12 December 2023
Clague ref: PM/30709B/199565

***Proposed MMA Application for alternate window design
21-31 High Street, Whitstable***

Drawing Description
Proposed Elevations

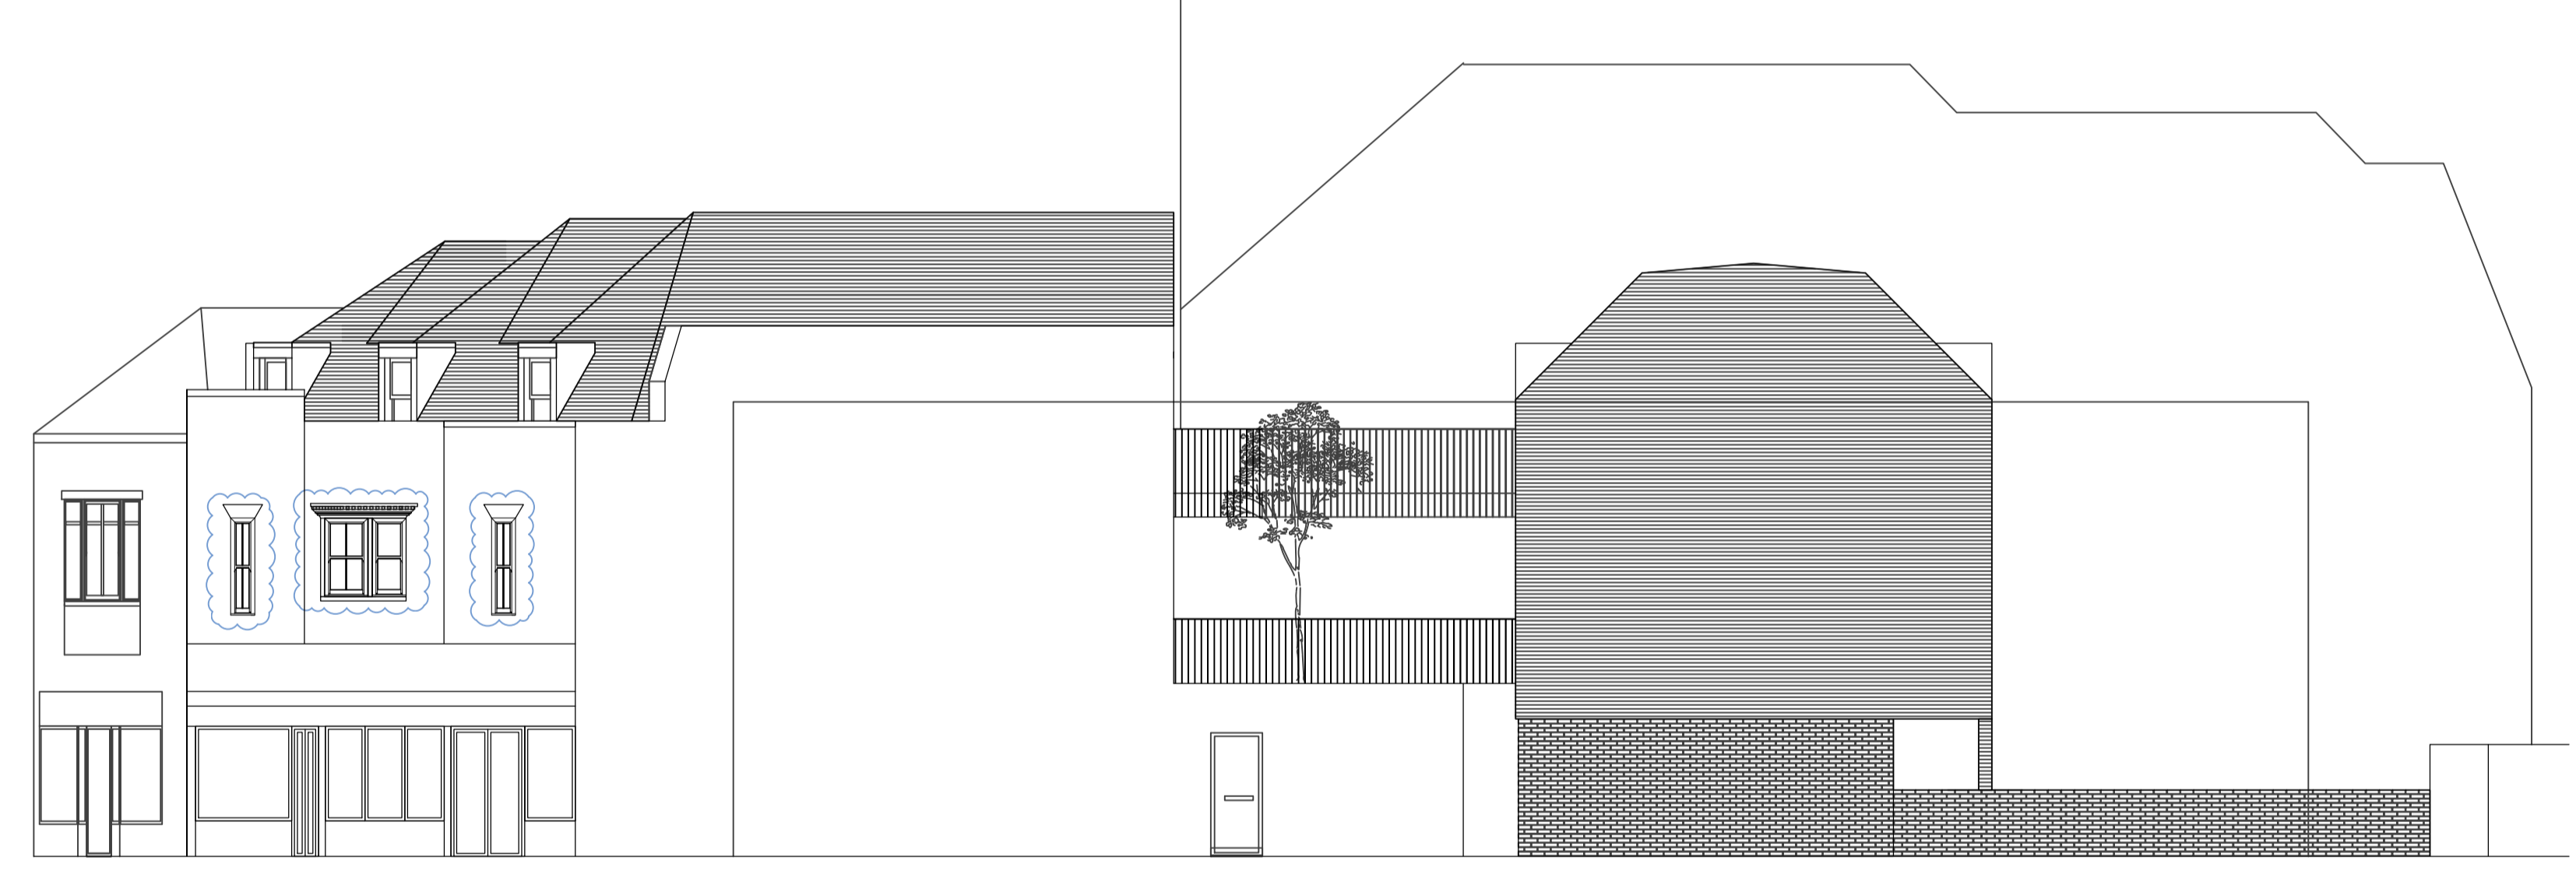
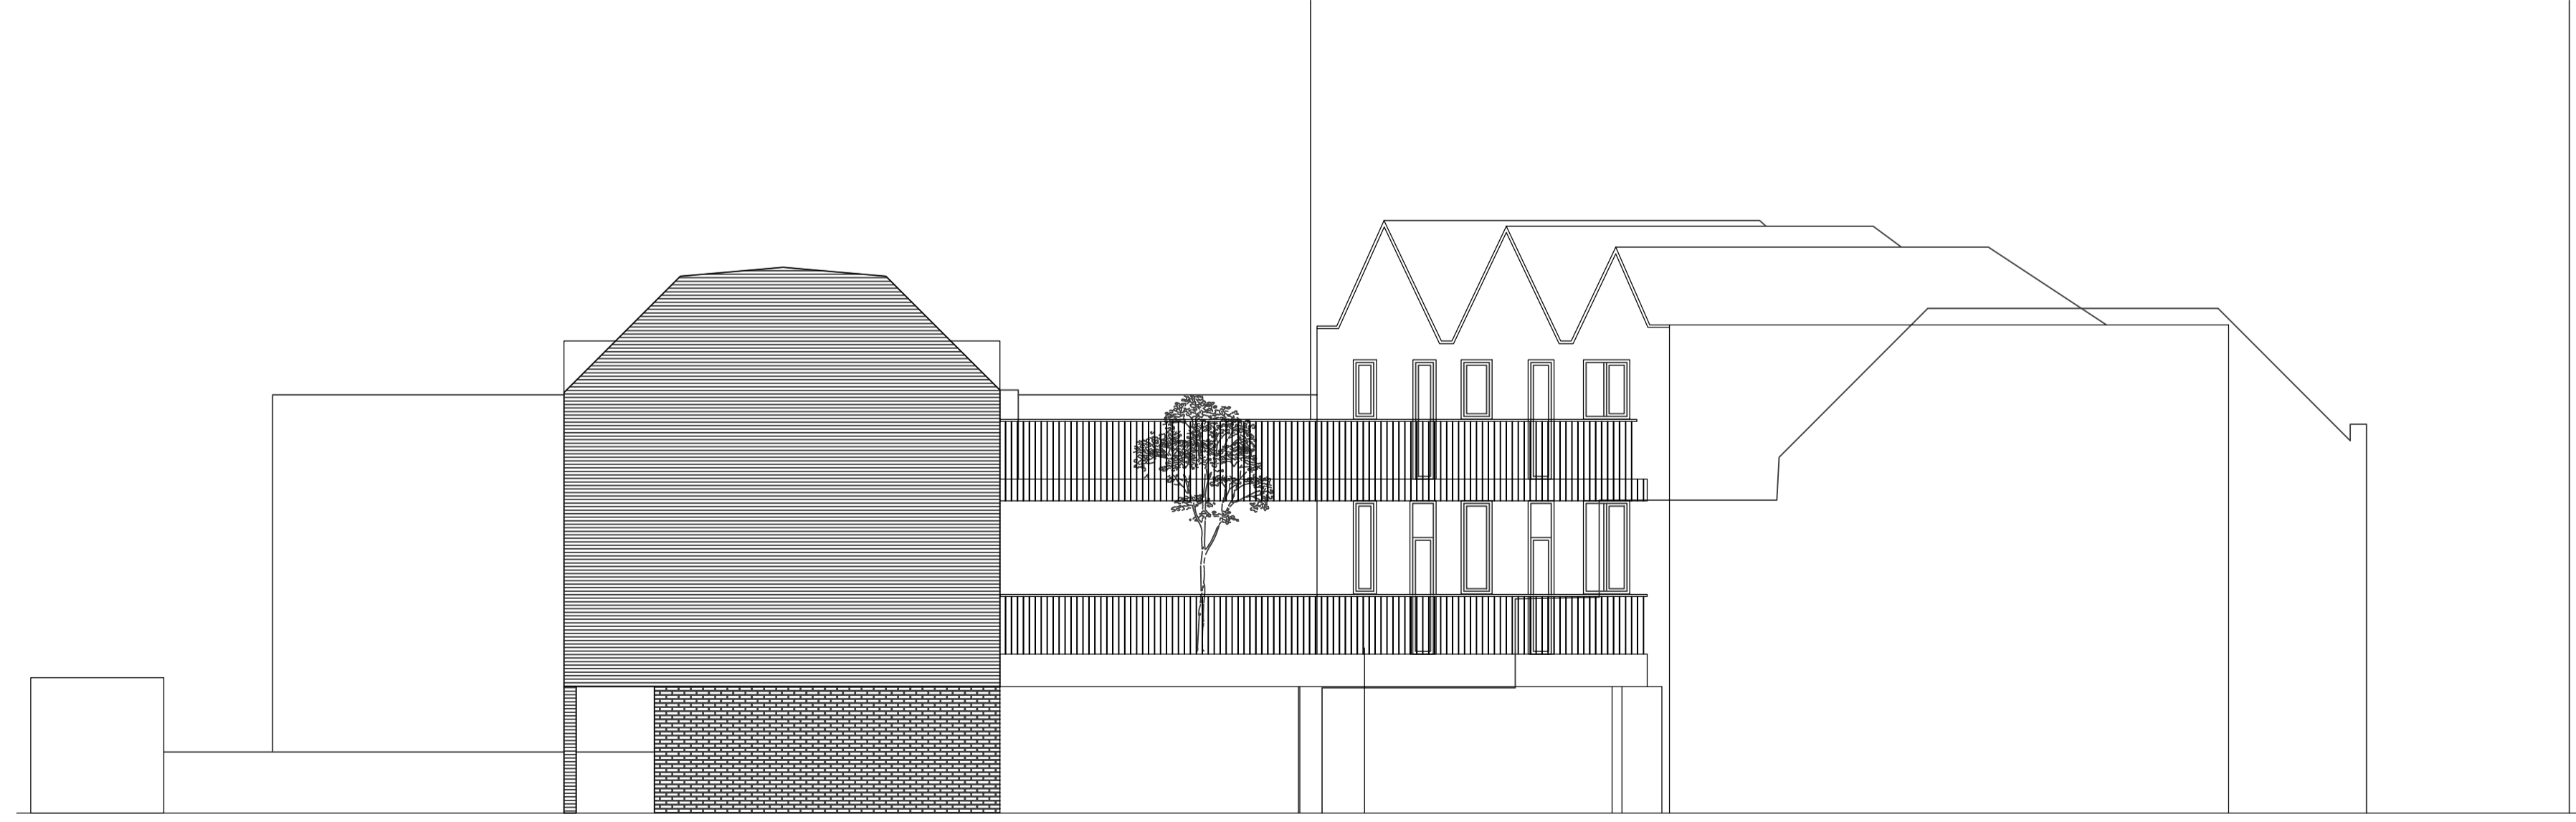
The change involves the 3no. first floor windows and is intended to improve the aesthetic of what has been previously granted consent. The right hand side window when facing the development from the High Street will have the existing modern horizontal casement window replaced by a more appropriate vertical sliding sash window and the central bay is to have its central support removed along with the modern casements, all to be replaced by 3no. vertical sliding sash windows. The left hand side window is to remain essentially as approved, albeit the height will be slightly adjusted to align with the internal finished floor level.
